Please ask for: Jonny Cooper
Email: jonny.cooper@arun.gov.uk
Telephone: 01903 737532
Our Ref: FG/14/25/PL
Your Ref:
Date: 28th January 2025

Application for Planning Permission

Development: Partial removal of rear extension of 275 Goring Way and erection of 1 No. self-build chalet bungalow in garden of 275 Goring Way with associated landscaping and parking. This application is in CIL zone 4 and is CIL liable.
Location: 275 Goring Way Ferring BN12 5BY

A :: Existing South Elevation
01 scale: 1:100

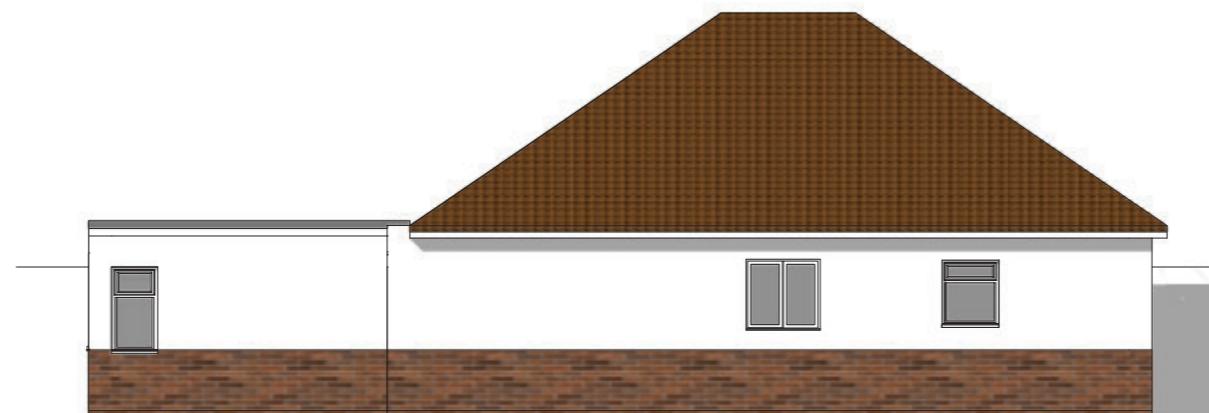
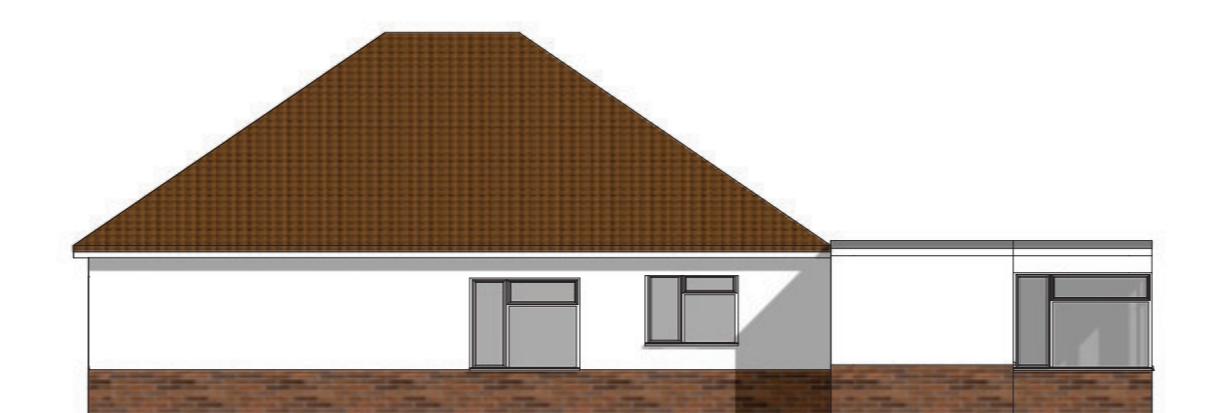
The door serving the porch on the existing ground floor plan should be viewable on the existing south elevation, but is not. Please amend these and resubmit the plans.
